From: Martyn White
Sent: 05 July 2019 09:39
To: Planning.Responses <Planning.Responses@arun.gov.uk>
Subject: AW/167/19/HH

AW/167/19/HH

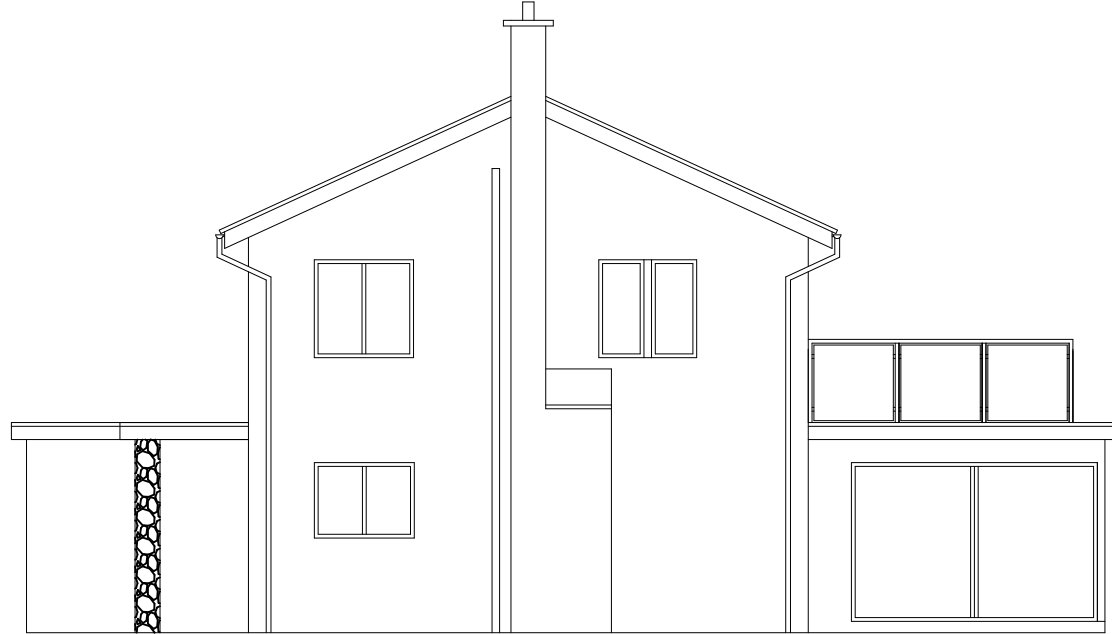
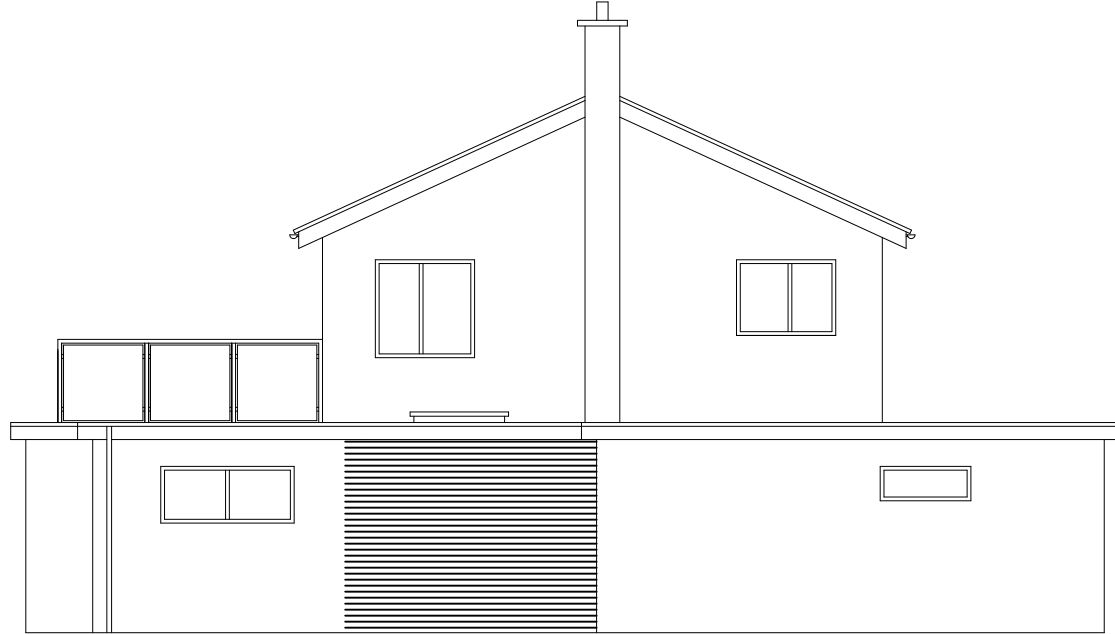
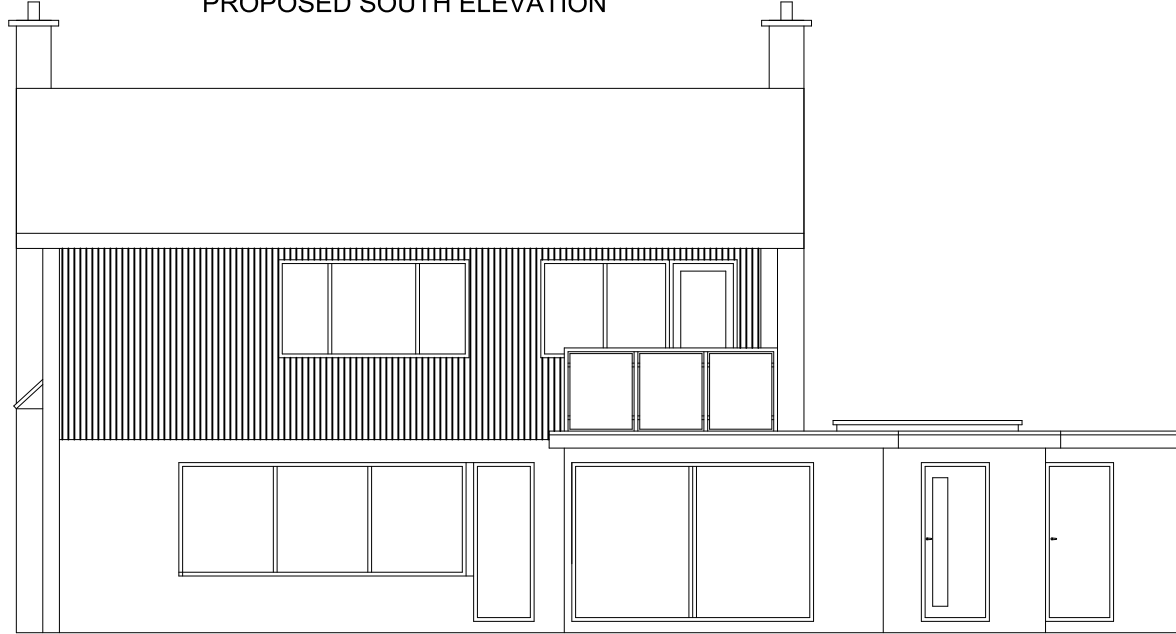
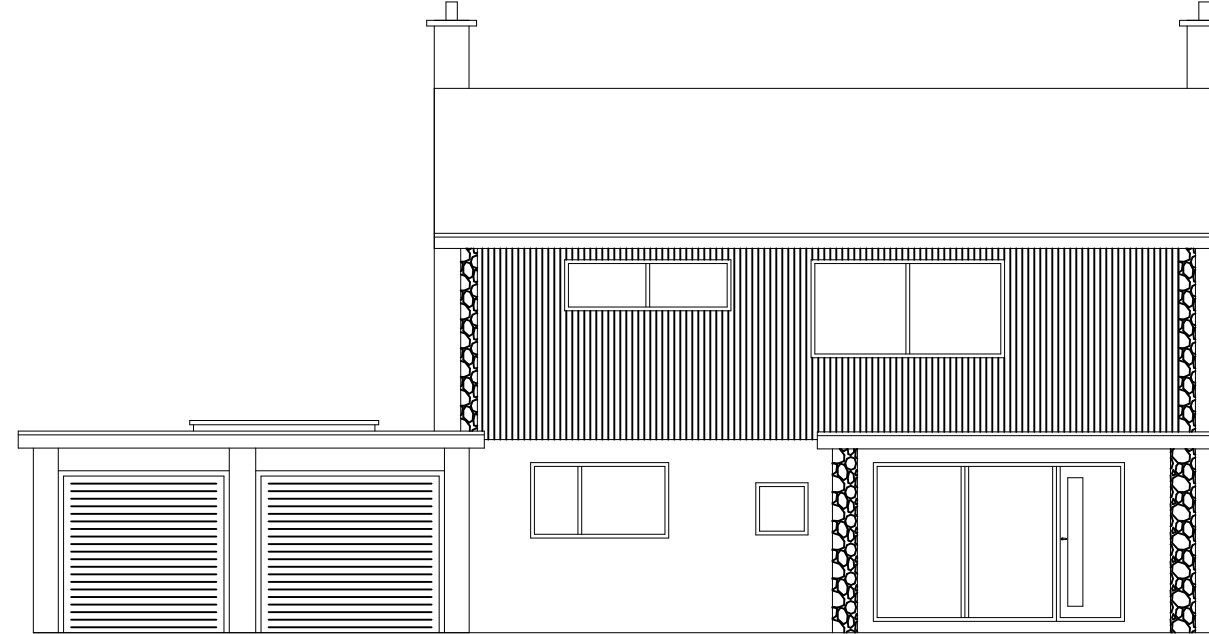
However, this is subject to the quality of the materials used. Having looked at the information it is not clear how the replacement cladding will look like in terms of appearance and treatment and should be designed to reflect the existing appearance/character of the building. Likewise, it is not clear what the stone cladding will look like. If minded to approve the application, details of the stone cladding, how the cedar cladding and the front door will look will need to be confirmed, and this could be done by condition, if you are minded to approve the application.
